Appeal Decision

Appeal Ref: APP/R5510/D/23/3321225

15 Church Avenue, Ruislip, Hillingdon HA4 7HX

- The appeal is made under section 78 of the Town and Country Planning Act 1990 against a refusal to grant planning permission.
- The appeal is made by Mr Steve Curteis against the decision of the Council of the London Borough of Hillingdon.
- The application Ref 26493/APP/2023/43, dated 6 January 2023, was refused by notice dated 3 March 2023.
- The development proposed is a two storey rear extension, a first floor side and rear extension, a single storey rear extension, a front porch extension and changes to the roof.

CONTEXTUAL ELEVATIONS

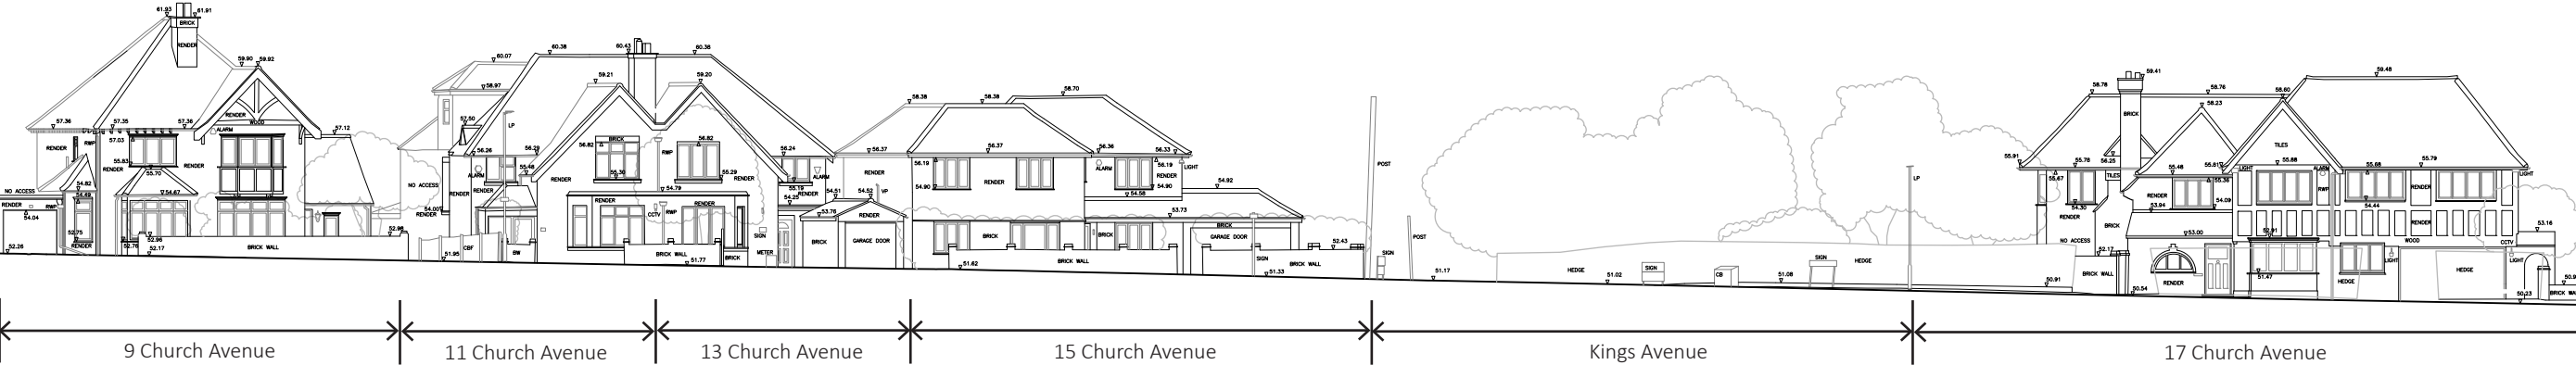
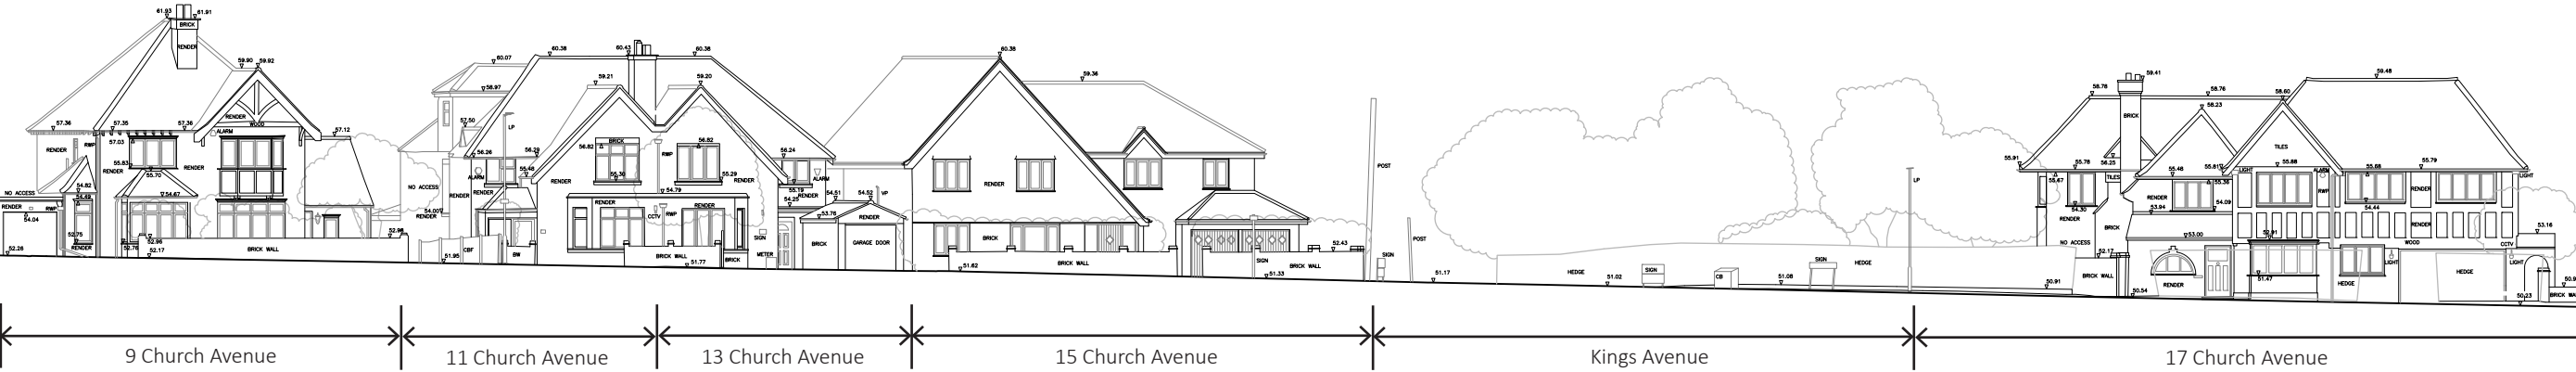
8. The proposed extensions would significantly alter the appearance of the existing building and would give it a greater scale and bulk. However, as demonstrated by drawing no. 2022-036/212, the highest point of its raised roof would be no taller than its neighbour at 13 Church Avenue ('No 13'), and its long ridgeline parallel to the road would be lower.
